27 November 2012

Response to Submissions
Dubbo Base Hospital – Redevelopment Project - SSD-5250

DUBBO CITY COUNCIL'S REQUEST FOR ADDITIONAL INFORMATION

A sketch is included with this statement to indicate the stormwater drainage system.

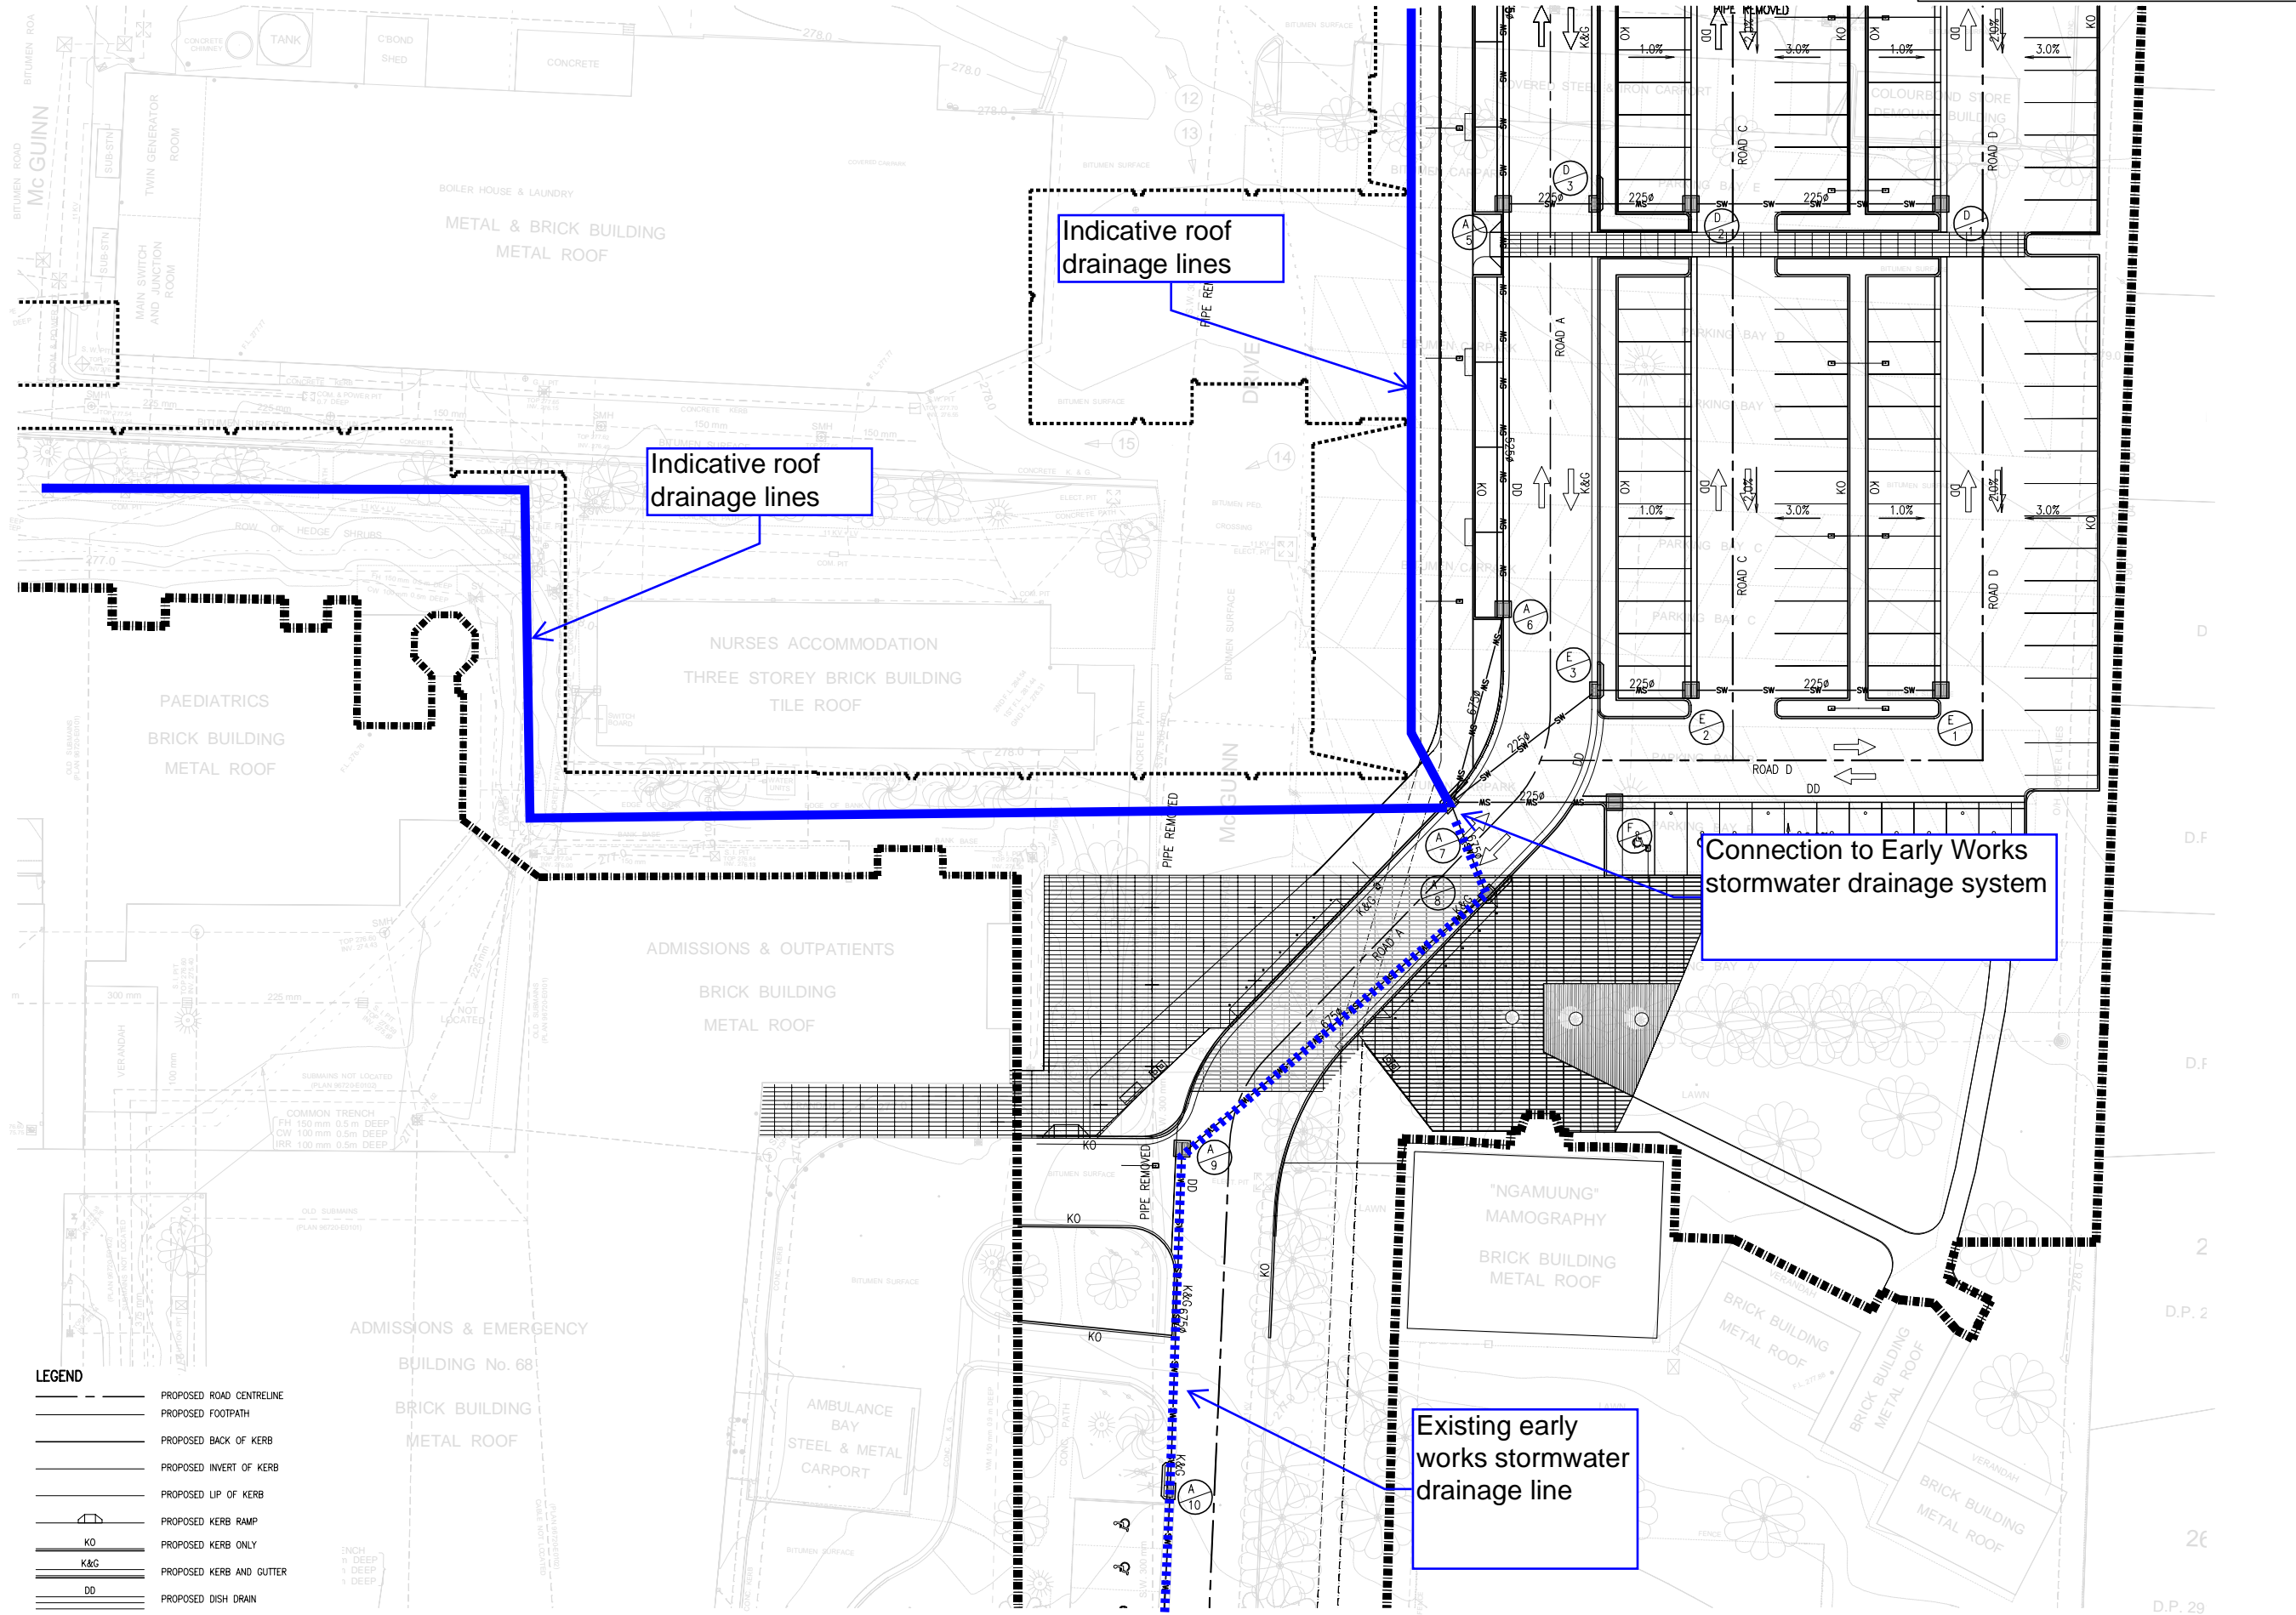
“There is no information in relation to the drainage to the north towards River Street including information on water quality, gross pollutant traps, etc. Also there is no overall catchment plan supplied for stormwater management.”

“It is considered that the interaction of the detained flows with the existing catchment flows need to be addressed so that the peak flows do not coincide to create an issue. In addition, the overland flows along Myall Street will end up in the railway drain, which may be an issue in larger events.”

"The downstream underground system may not be a 1 in 10 year system. Council design standards require that this system be designed to a 1 in 10 year system."

"It is unclear if the design takes into account any upstream flows from the east and whether they impact on the proposed development. In addition it is unclear if the design allows for future expansion of the site or is it expected that further development will remain within the existing building footprint."

Refer to Section 5.3.2 of the enstruct report at Appendix D of the REF. This addresses drainage to the north of the site via the railway corridor.

The OSD tank draining to Myall Street will service the proposed car park; a trash rack is installed within the OSD tank with a sump to capture gross pollutants and sediment before discharging into Myall Street drainage system.

The OSD basin (north west boundary) will have a 200mm sump to collect any sediments and free oil from the first flush. Expected gross pollutant from driveways will be captured in the grated pits before entering the underground system.

Stormwater Management Report, Section 5.6.1 – Myall Street Detention caters for all design runoffs up to and including the 20 year ARI. The discharge into Myall Street underground system is restricted back to the pre-development 5 year ARI. Due to the new drainage system, overland flow on to Myall Street will be significantly reduced for any storm events greater than 20 years ARI. Therefore no additional overland flow will end up in the railway drain, compared to current conditions.

The OSD design restricts the discharge to the 5 year ARI pre-development runoff. As outlined in Stormwater Management Report, Section 5.6 for both discharge points.

Impervious areas from the eastern properties fronting Leonards Street are drained via kerb connection. Remaining overland areas grades to the east towards Leonards Street. The current Myall Street detention system is designed for the proposed development. The existing volume to earth basin situated in the north western corner will be increased to 115m³ and is designed to allow for future expansion.
